Consultation Response from: KC Environmental Health (Pollution & Noise Control)
2021/93674 Greenhead College, Greenhead Road, Huddersfield, HD1 4ES
Partial redevelopment of Greenhead college including demolition and making good, erection of 2 and 4 storey buildings, reconfiguration of parking and access arrangements, reconfiguration of sports provision and other associated external works (Within a Conservation Area)
Date Responded:

Responding Ref:

WK/202133587

ON NOISE RELATED ITEMS

Figure 7: Noise barrier to the roof level plant area west elevation

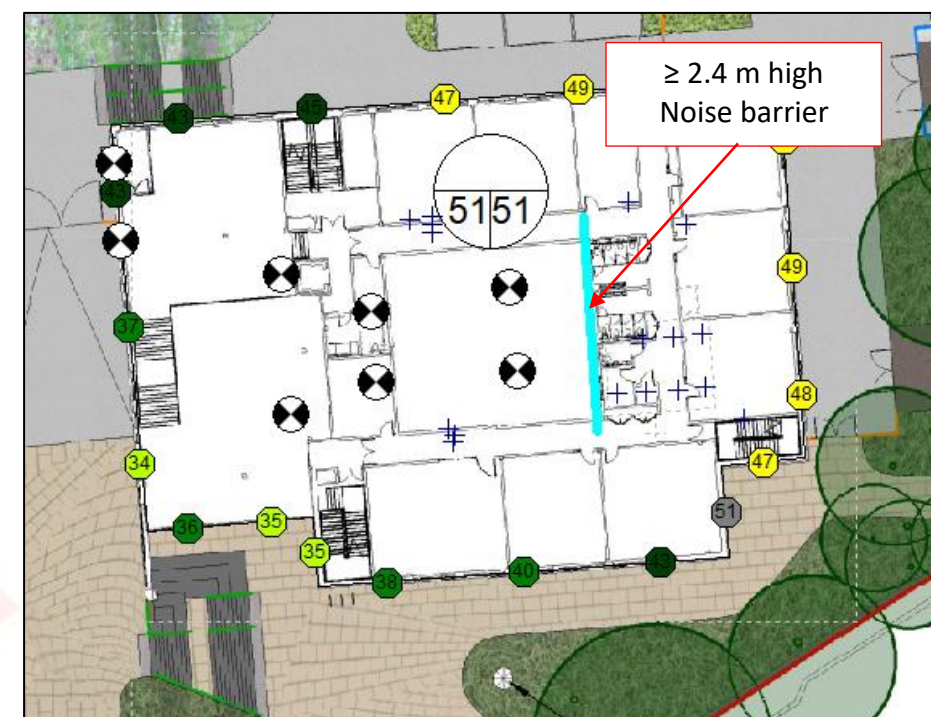
The report continues to also recommend additional mitigation measures for the new teaching block rooftop area to mitigate the noise impact from the fixed plant on the roof of the new teaching plant at the classroom roof turrets. The recommendations are for a 2.4m high solid screen between the main plant and the natural ventilation roof turrets. The report advises that the barrier should have no cracks or gaps, be continuous to the ground, and have a surface density ≥ 12 kg/m².

(3) The report reads, 'The details of proposed building services plant including operating mode and noise data are subject to detailed design and were not confirmed at the time of writing. Further assessment will be undertaken when these details are confirmed'. The report then continues to recommend an acoustic barrier and indicate that 'additional acoustic treatments' may be necessary.

Commented [s7]: APEX ACOUSTICS 25.11.2021
Plant and attenuator selections shall be based on Apex NIA report Table 5 plant noise limits.
Detailed plant noise impact assessment based on BS 4142 at nearby dwellings shall be carried out once final plant selections have been confirmed.

Figure 8: Noise barrier to the west and south of the sports pitch

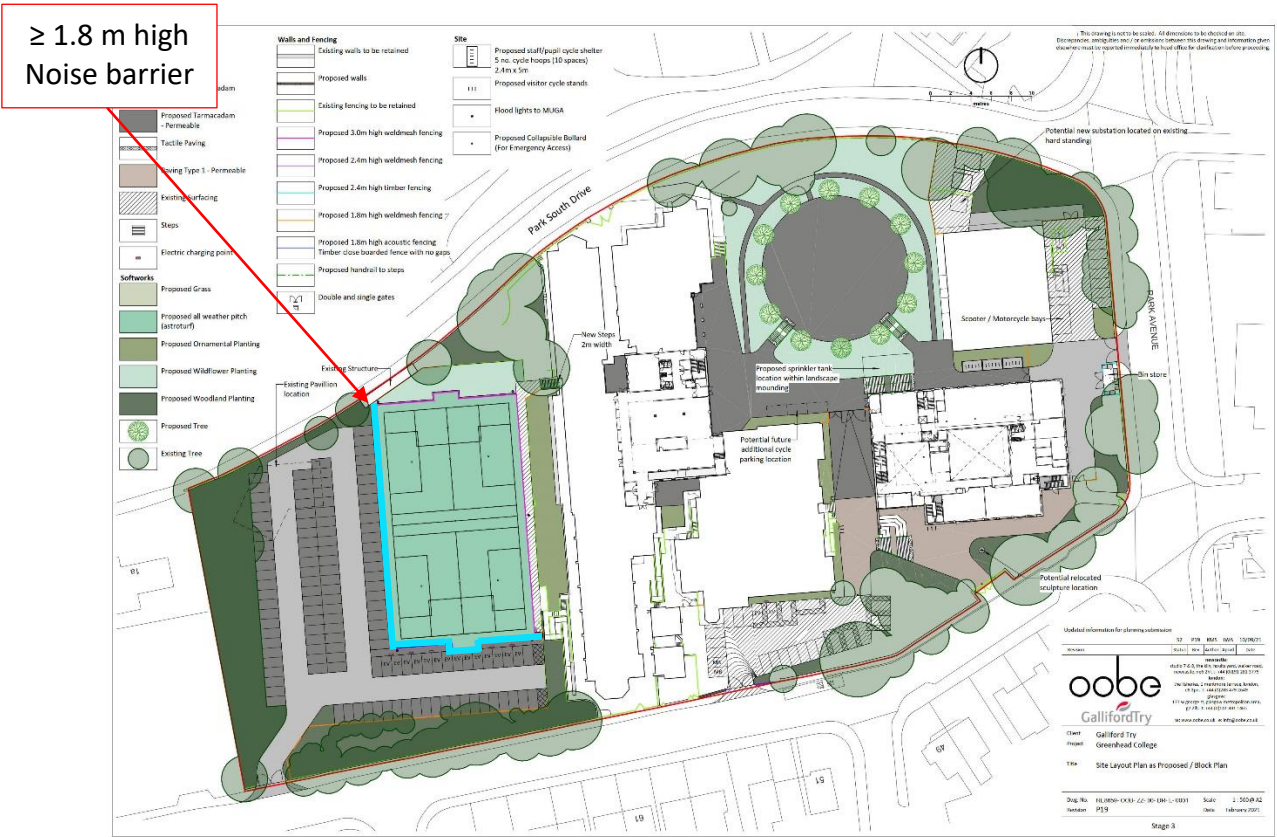
(5) We note the proposals for a close boarded timber fence such as an acoustic barrier around the west and south of the sports pitch. Any fencing to the pitch must be anti-rattle fencing. For the reasons detailed herein, a revised noise assessment and revised proposals for attenuation measures are necessary.
